From: Tom Errico <thomas.errico@tylin.com>
To: Helen Donaldson <HCD@portlandmaine.gov>
CC: David Margolis-Pineo <DMP@portlandmaine.gov>, Katherine Earley <KAS@portlandmaine.gov>, Jeremiah Bartlett <JBartlett@portlandmaine.gov>, Jeff Tarling <JST@portlandmaine.gov>
Date: 6/25/2015 8:56 AM
Subject: 72 Bishop Street - Final Traffic Comments

Hi Nell - The following represents a status update of my preliminary comments.

**Title:**  
CONSTRUCTION MANAGEMENT PLAN

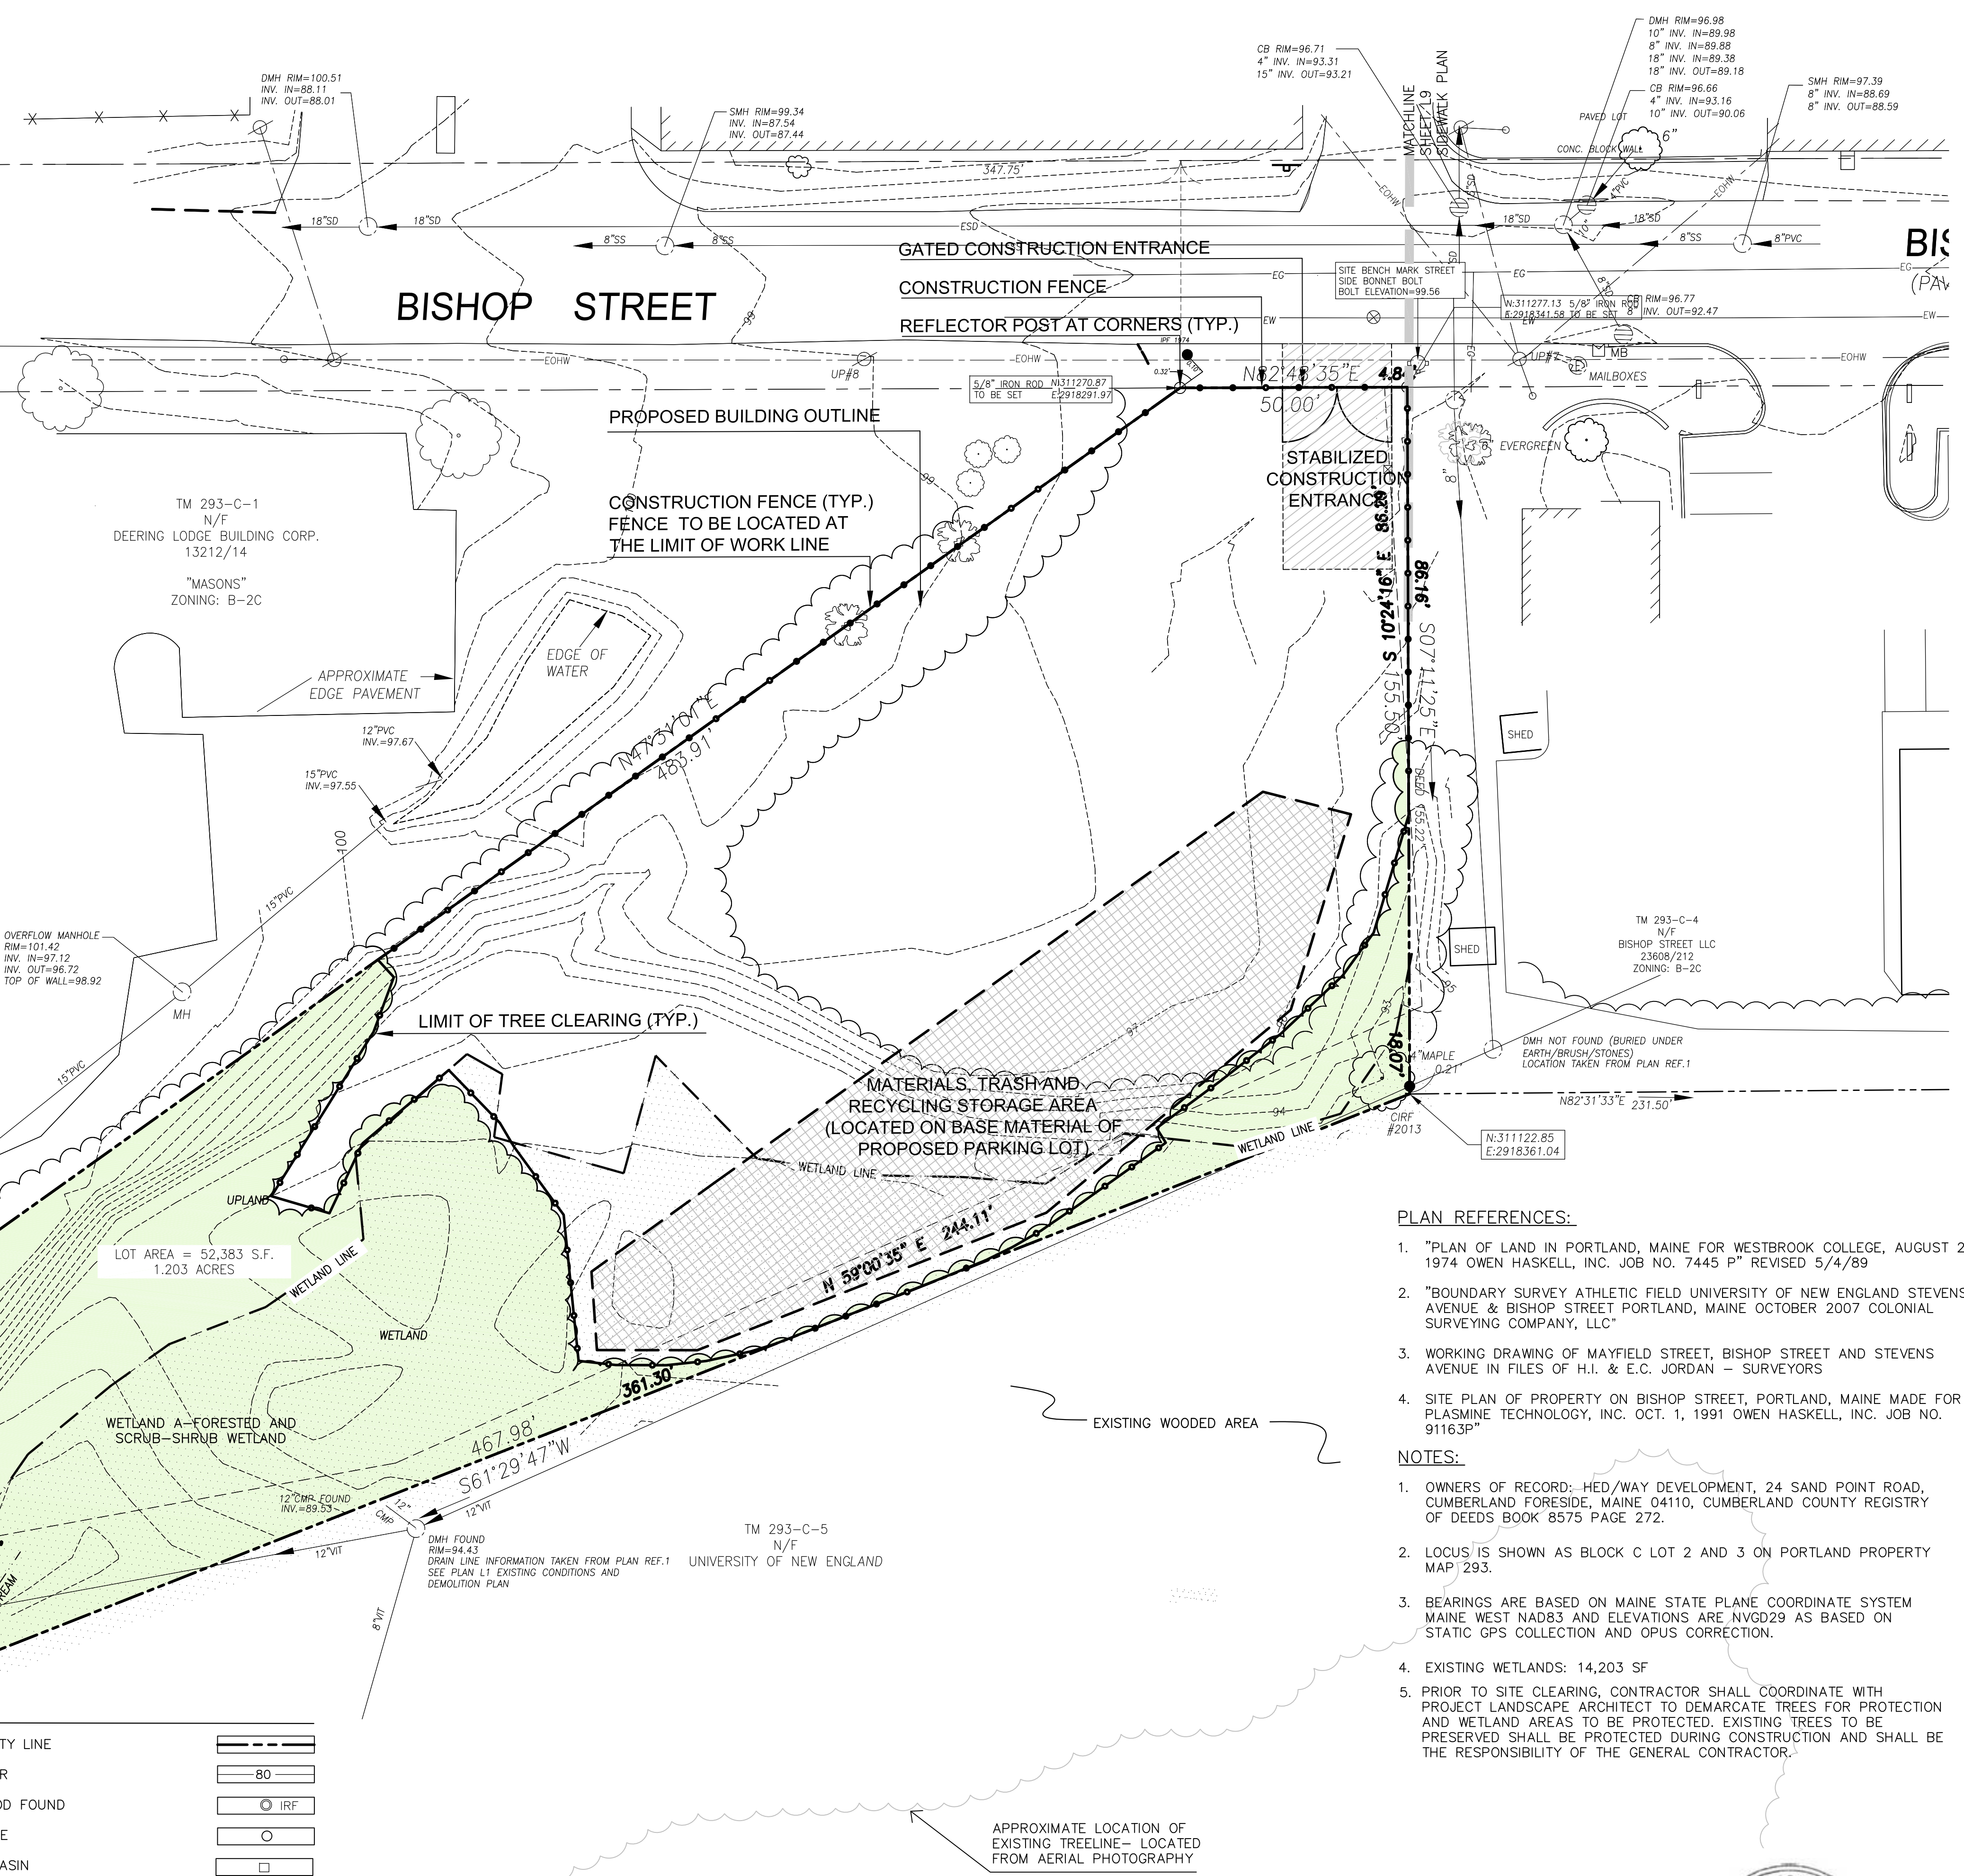
* The applicant should provide general details as it relates to a construction management plan. I do not support a waiver for this request.
Status: The applicant has submitted a construction management plan for site work and I find it to be acceptable. A construction management plan for construction of the sidewalk will be required and should be submitted for review and approval.

**1 SIDEWALK EXTENSION**  
 SCALE: 1"=10'

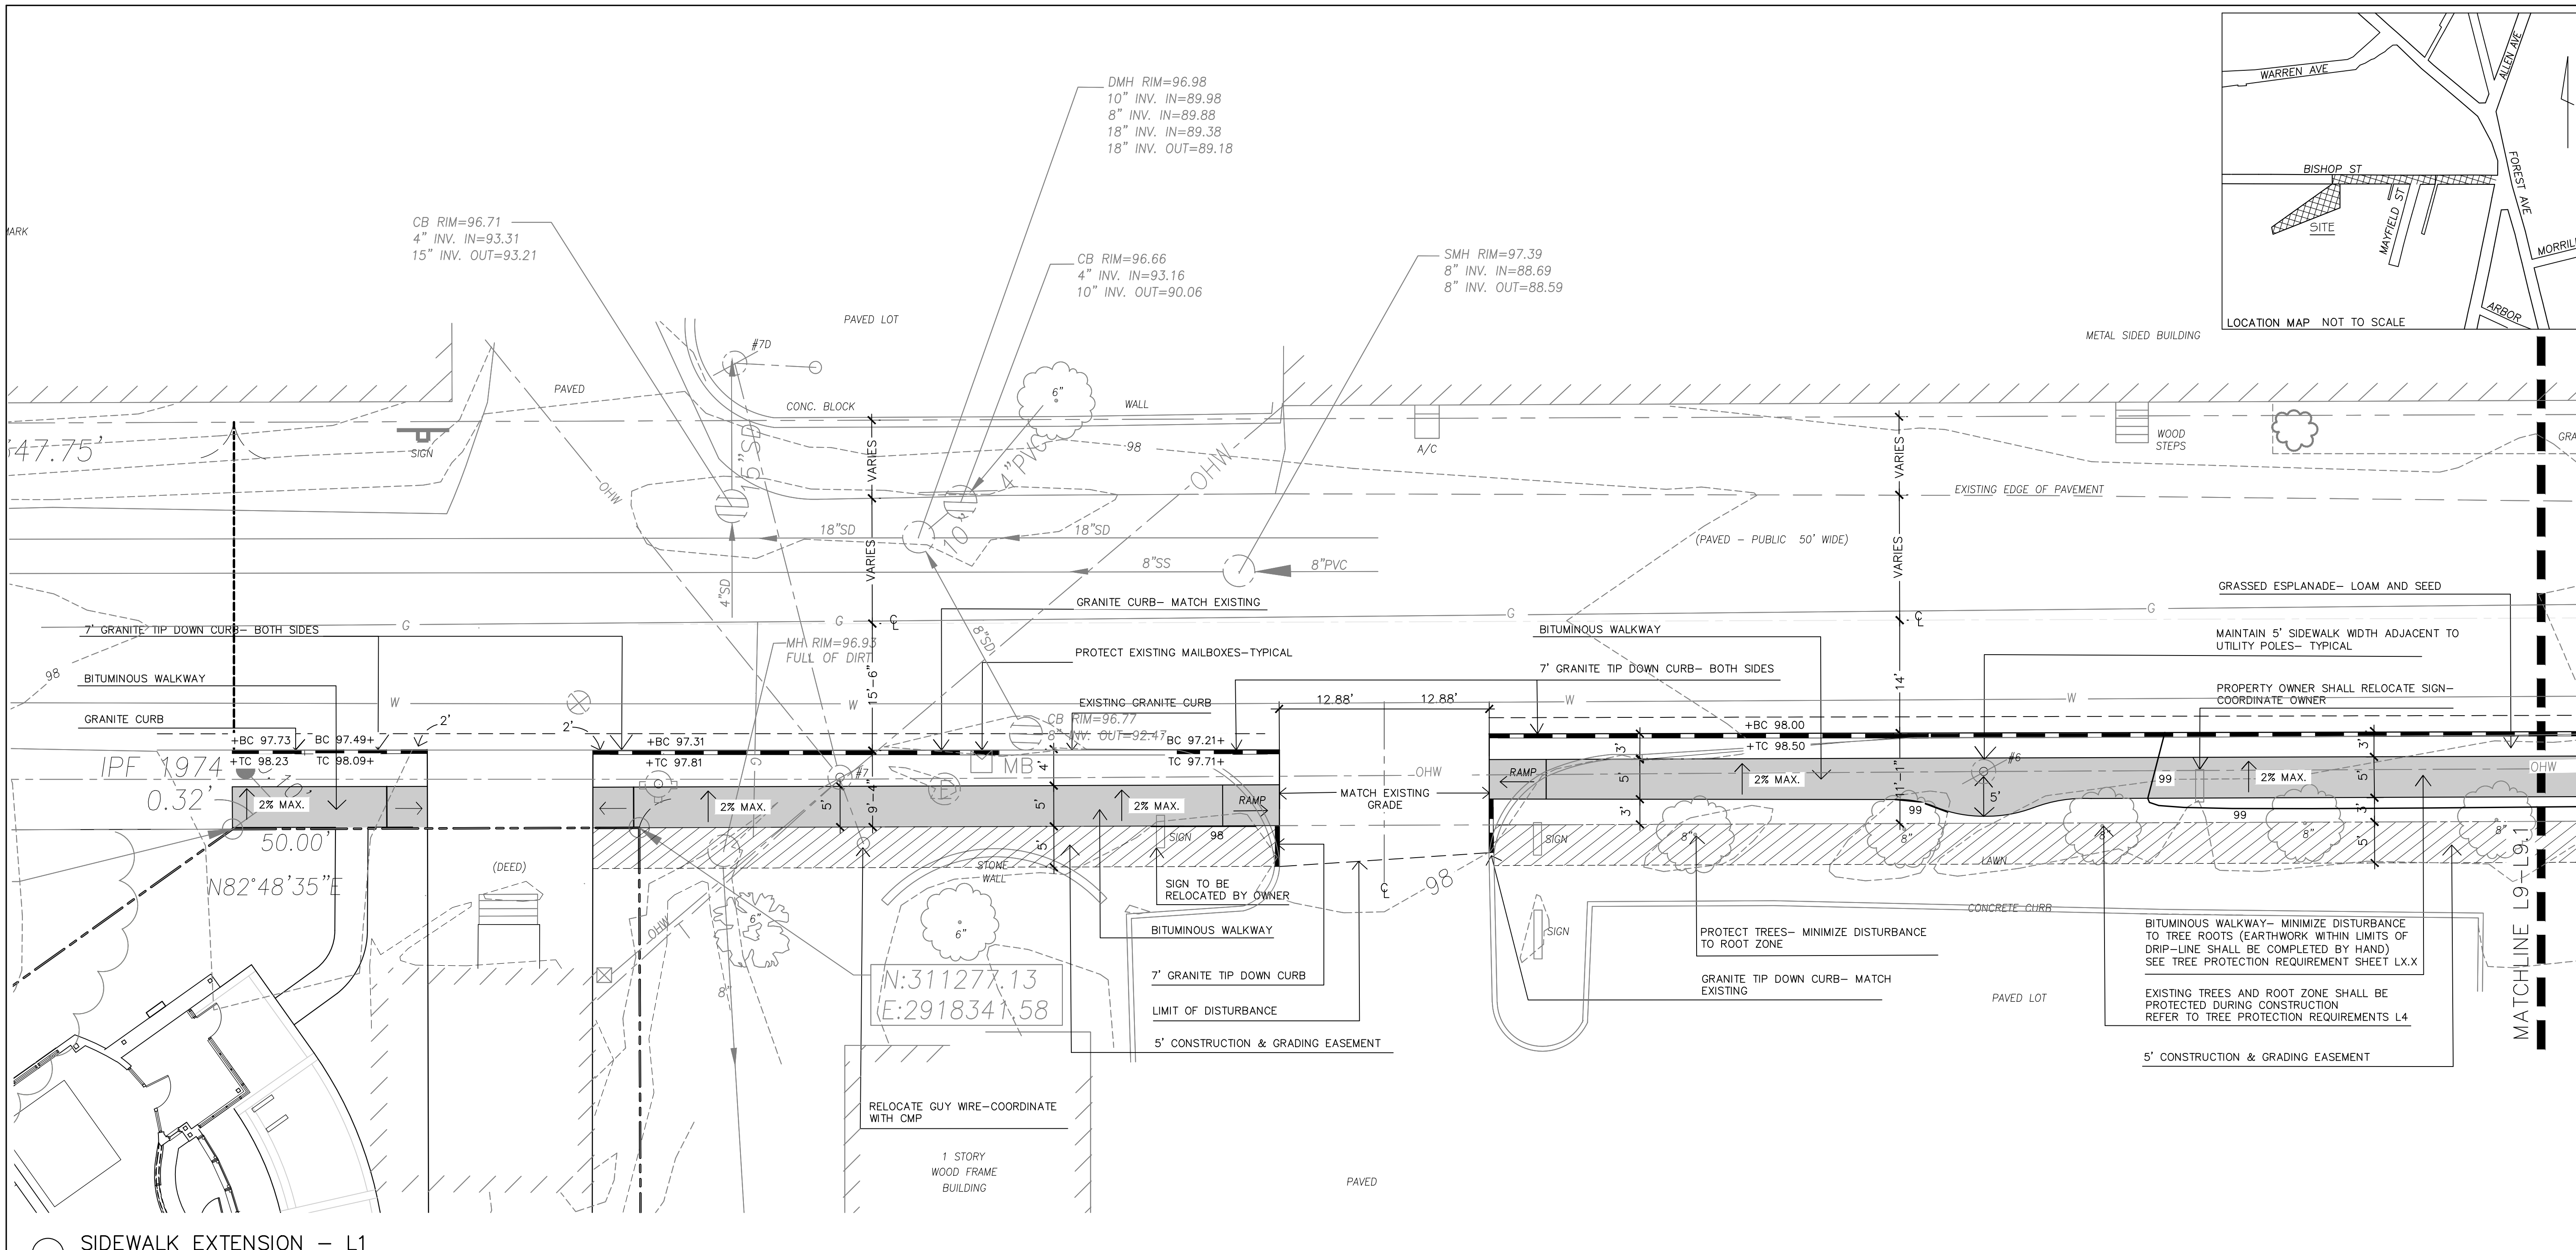
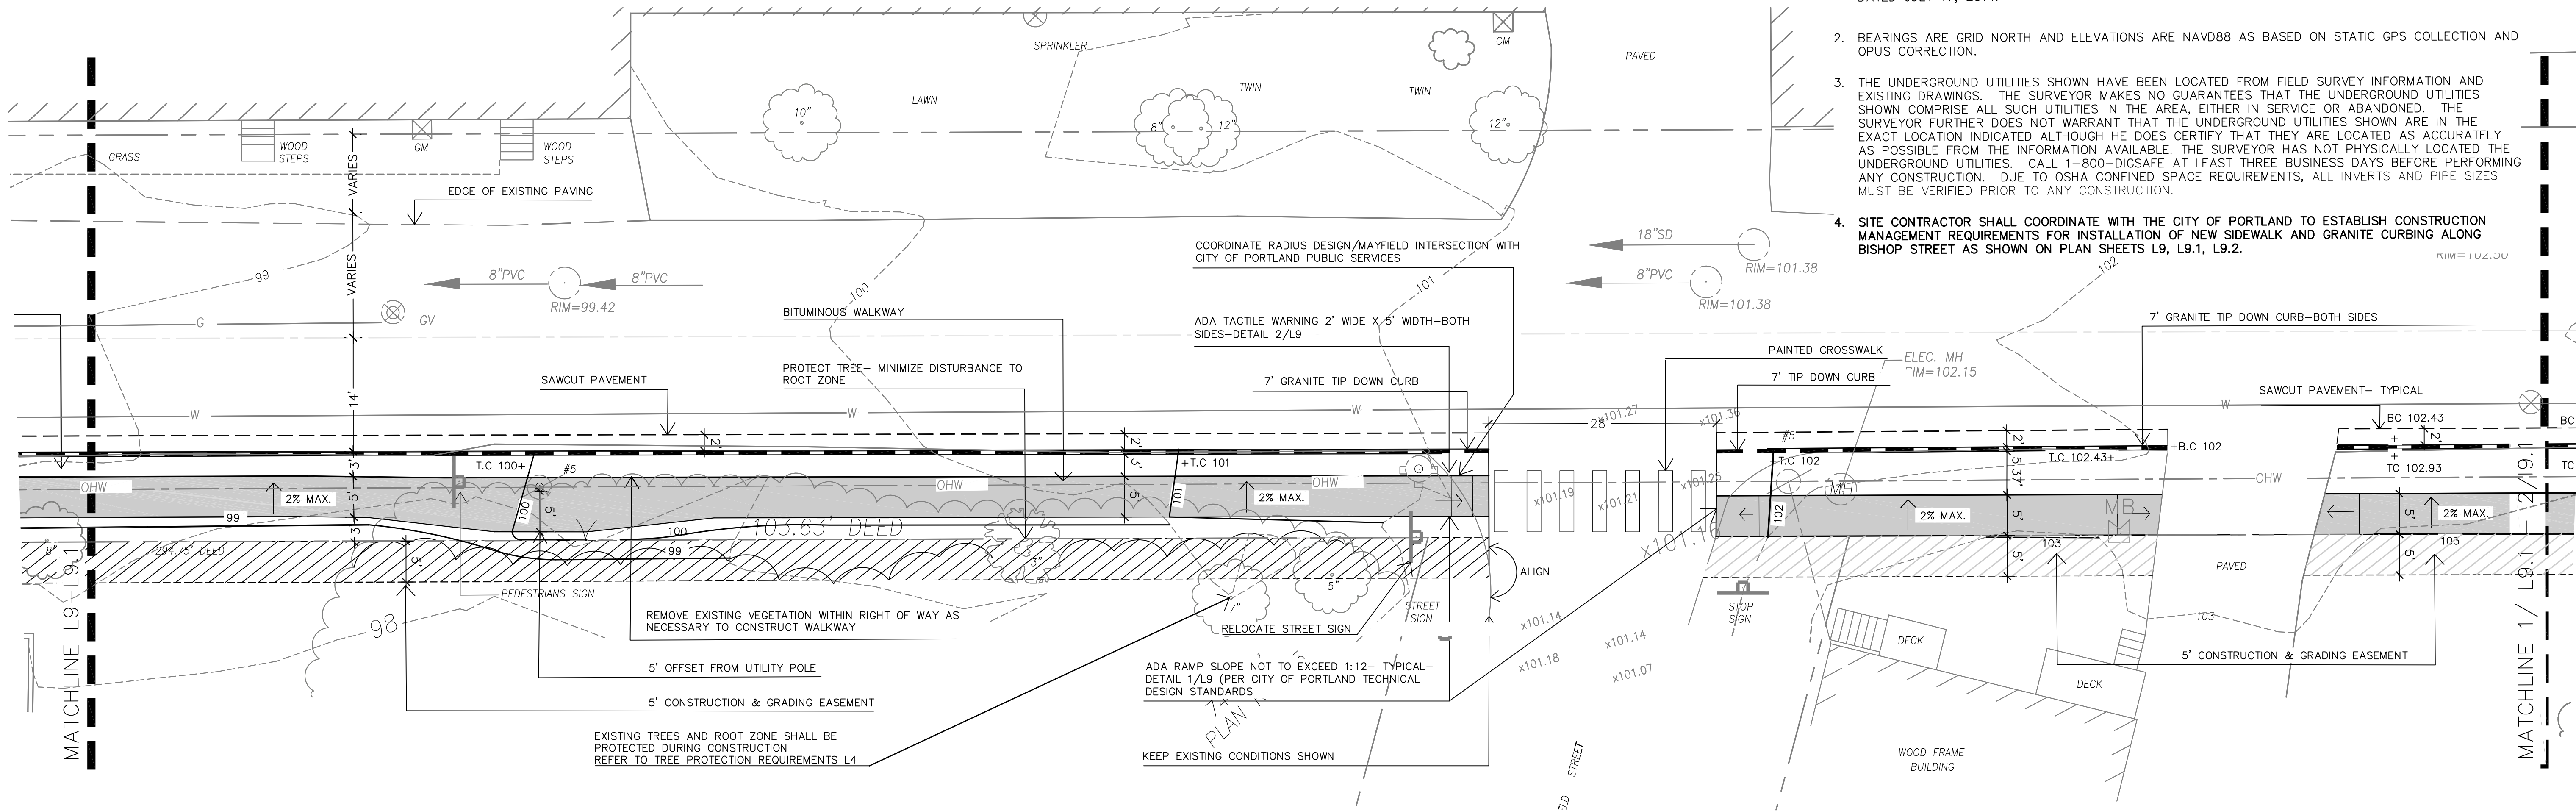
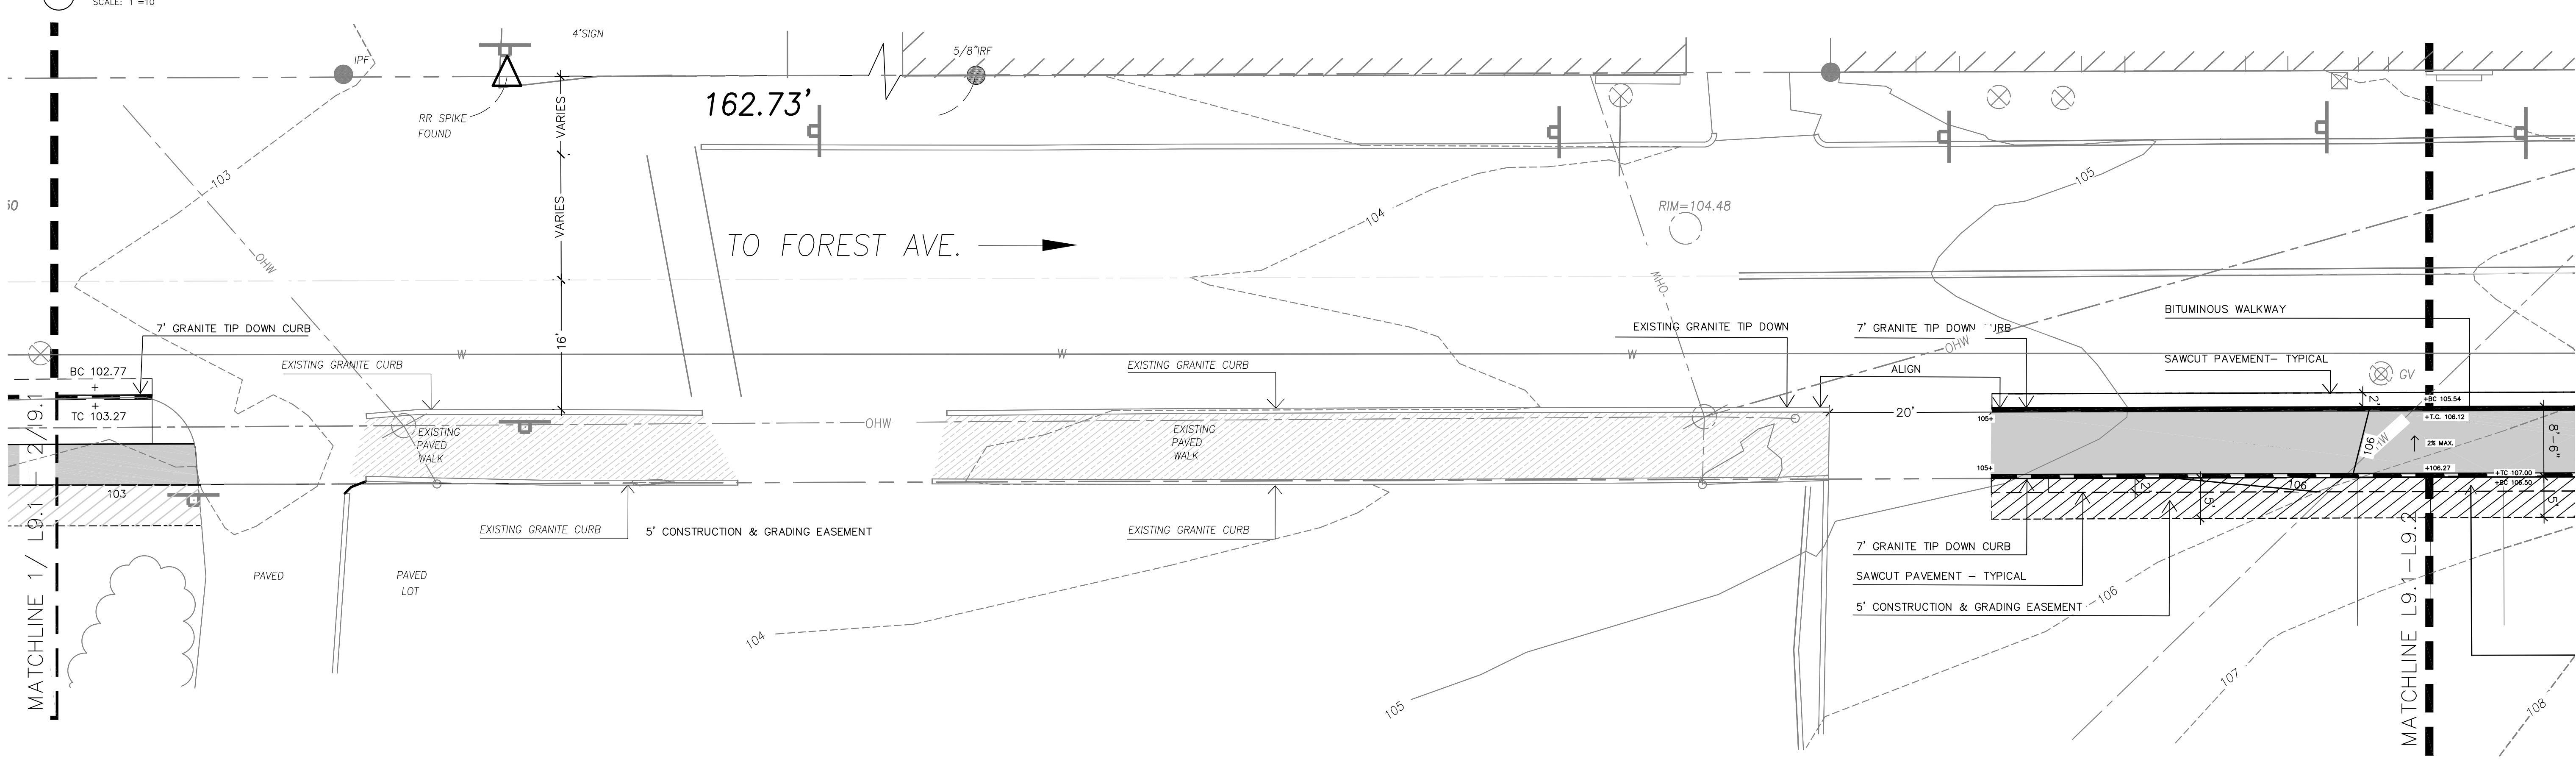
* A sidewalk is being constructed on Bishop Street, as identified during the zoning amendment process. I find it to be acceptable although the sidewalk should be extended to the corner at Forest Avenue/Stevens Avenue. I would suggest that the applicant develop a concept plan for review and approval. I can work with the applicant in the development of the plan from a traffic perspective, particularly how it interfaces with the existing parking lot.
Status: Upon receipt of revised plans with the extended sidewalk, I will review and provide comments. As noted above, I view a full safe sidewalk facility to be imperative.
